Subject: RE: Y/9818/RES and Y/97/18/DOC

Laura Gibbons, MEng, GMICE
Engineer (Drainage & Coastal)

Comments on the revised drainage and landscape proposals:

scheme: Land off Burndell Road
Yapton
client: Bovis Homes
drawing: Hard Landscape Proposals
date: Nov. 2018
scale: 1:200@A1
drawing no: BOV22172 12E sheet 1
drawn: AE checked: DKM

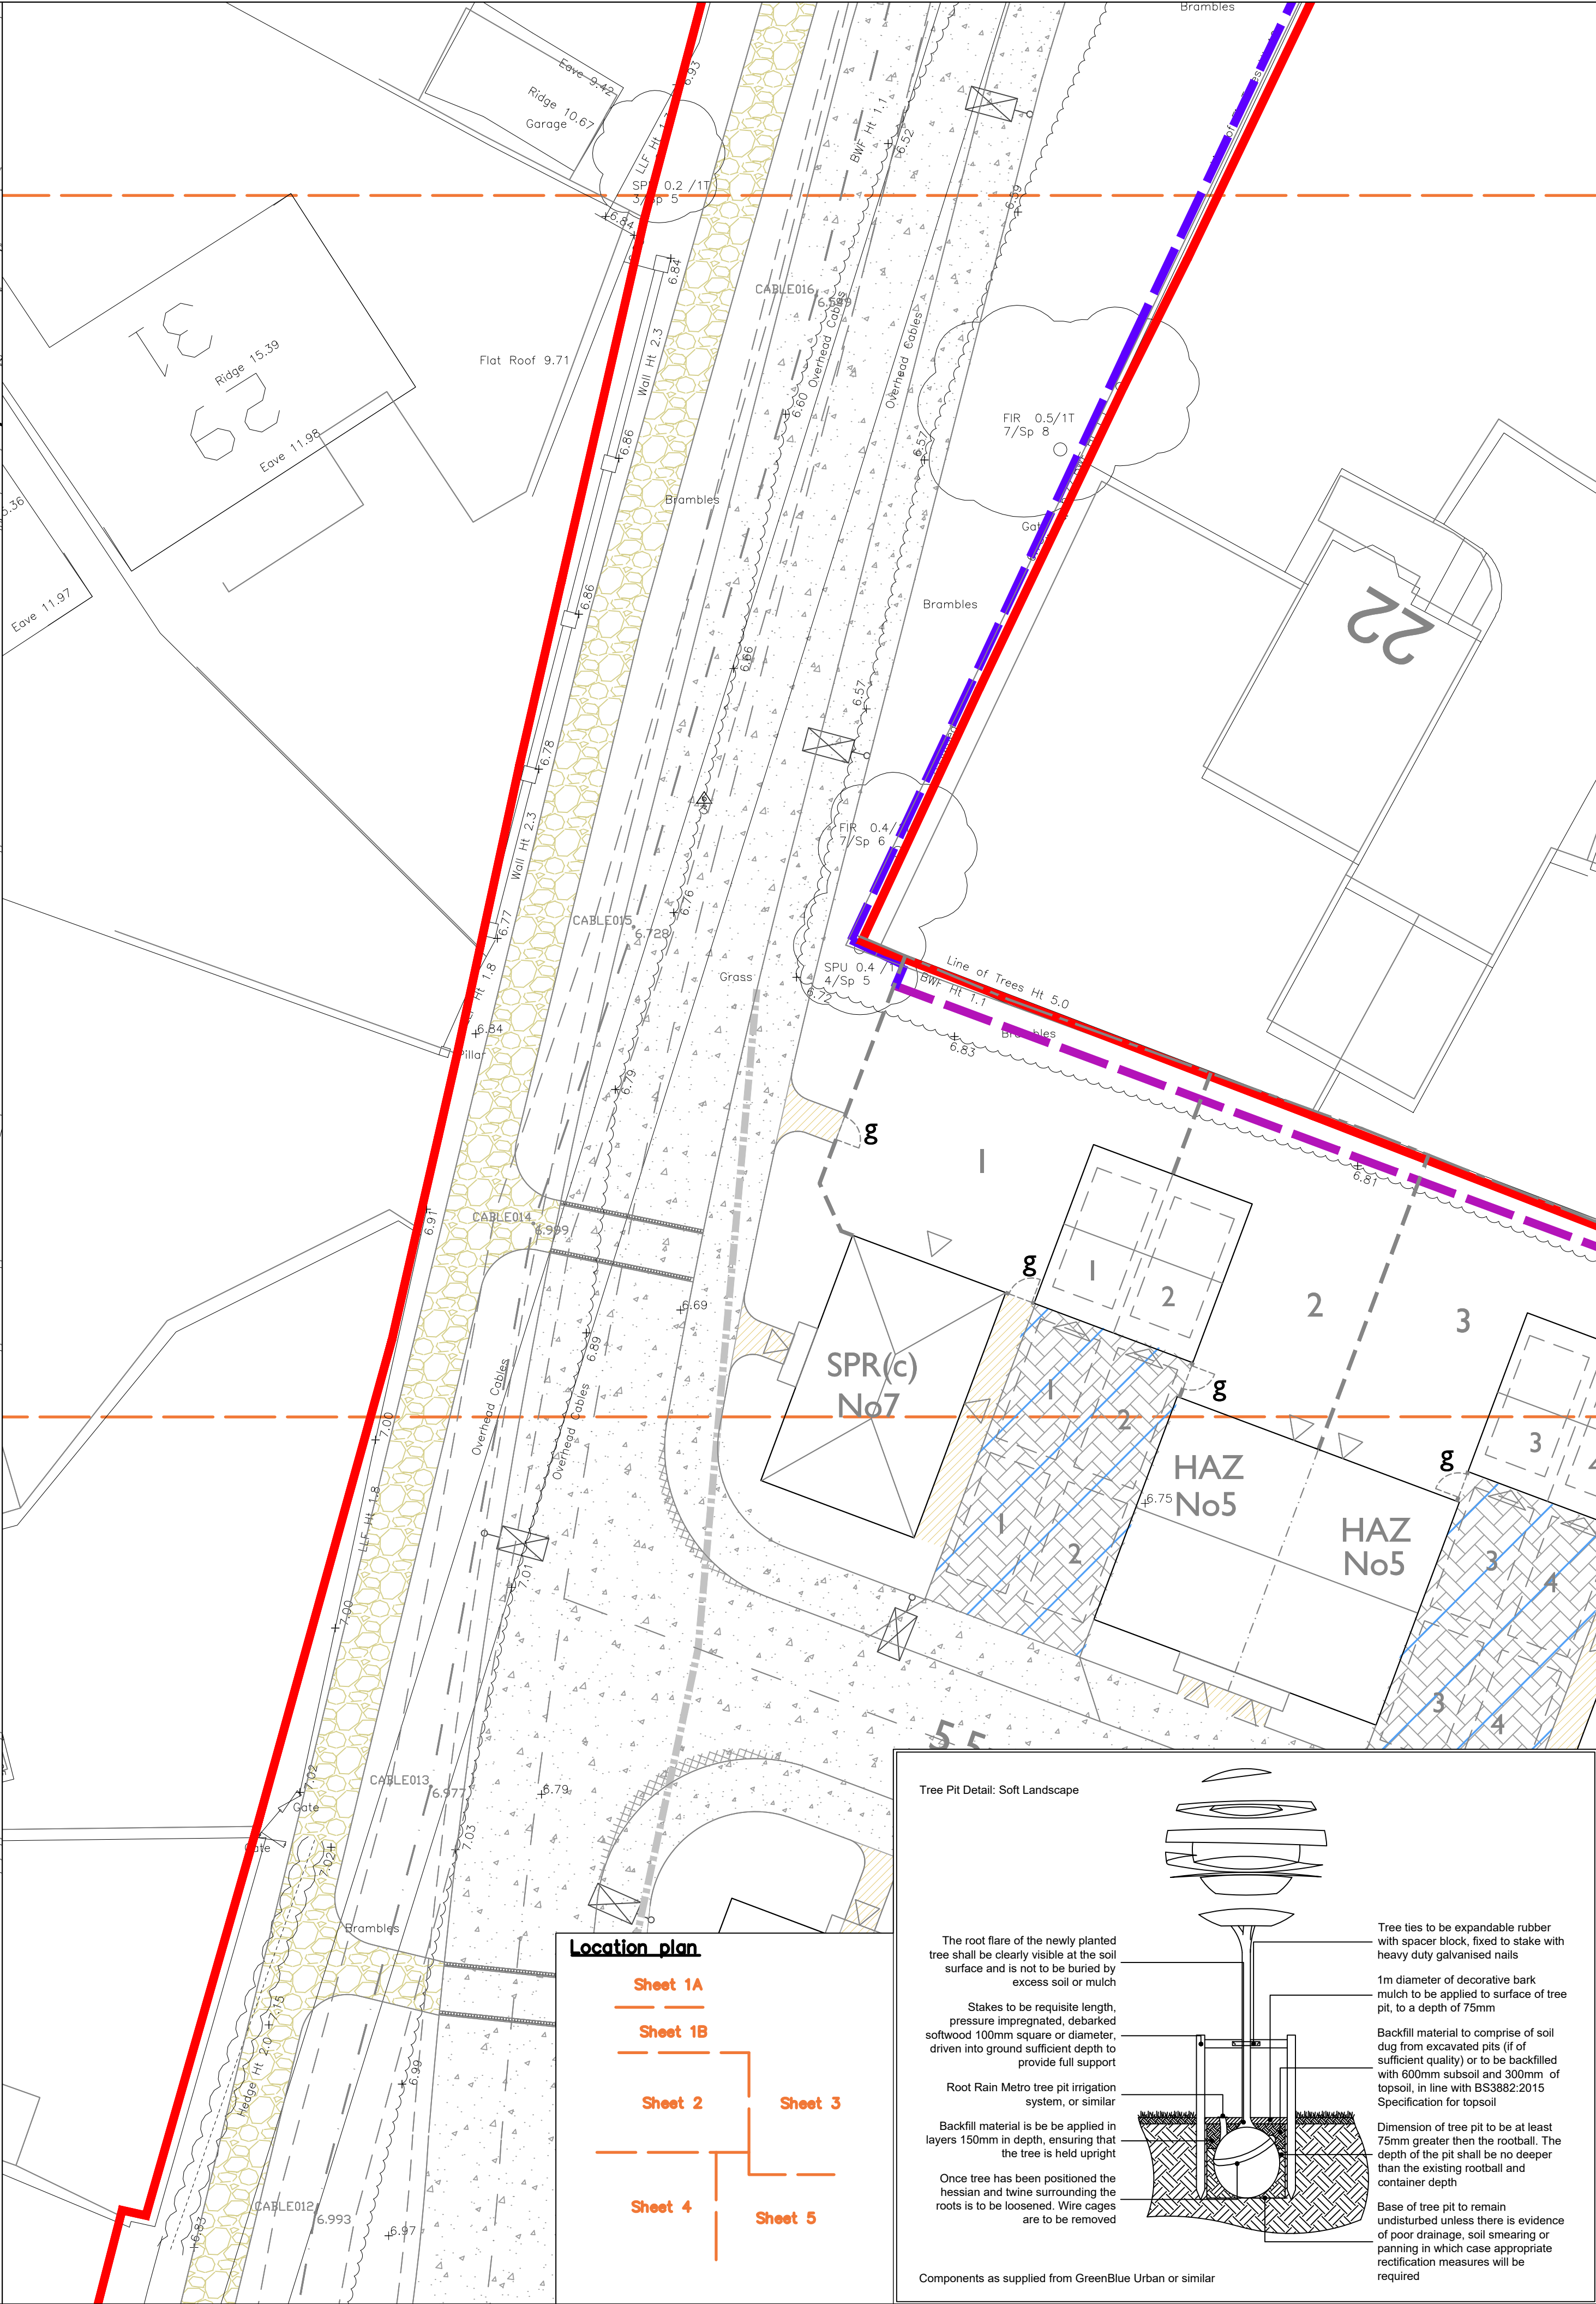
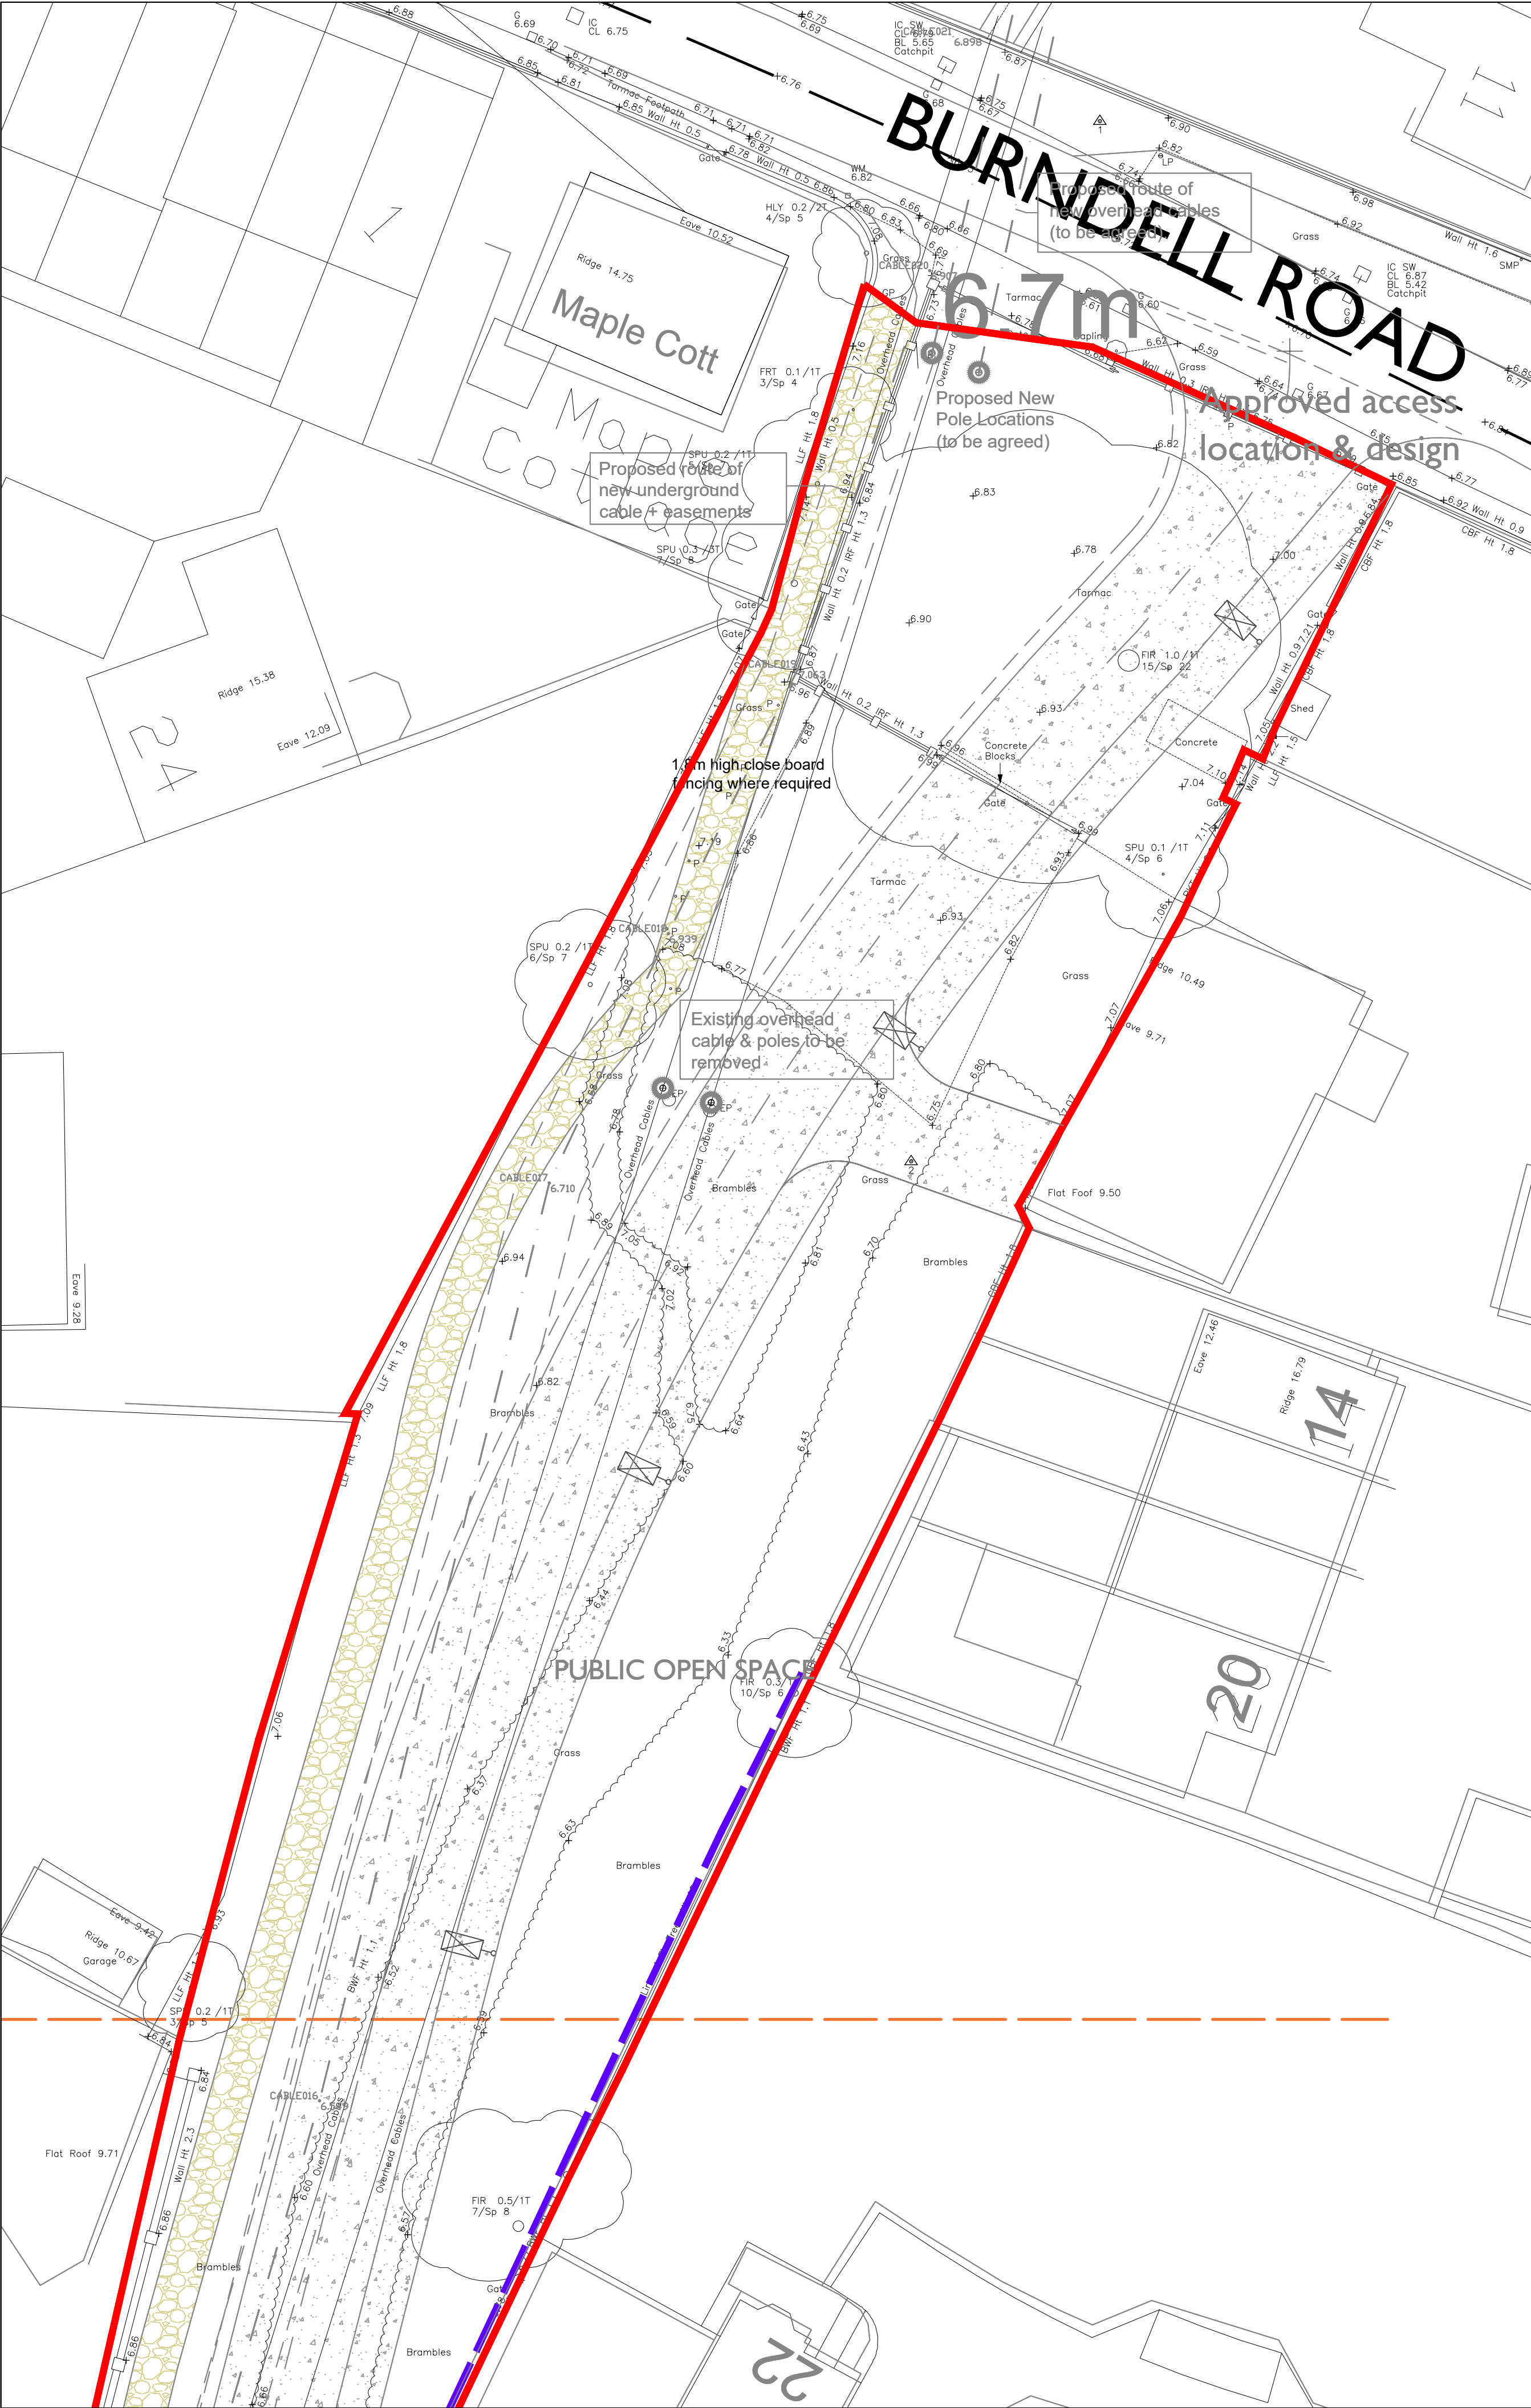
1. ACD have shown tank footprints on their landscaping plans. Updated plans provided. *These plans do not show the root potential areas. This is required.*

1. There are still trees proposed in close proximity to the southern-most attenuation tank. 2 no. trees close to this tank have been removed. Refer to updated ACD landscaping drawings. *On the ACD landscape drawing sheet 4 revision G there are trees in close proximity to the crate nearest the pumping station. Please can a plan be provided which shows both the proposed drainage and the proposed planting and associated potential root areas on the same drawing.*

1. ACD have added root potential areas representing a BS5837 RPA based on maximum expected stem diameter of 500mm. Refer to updated ACD drawings attached. *Okay.*
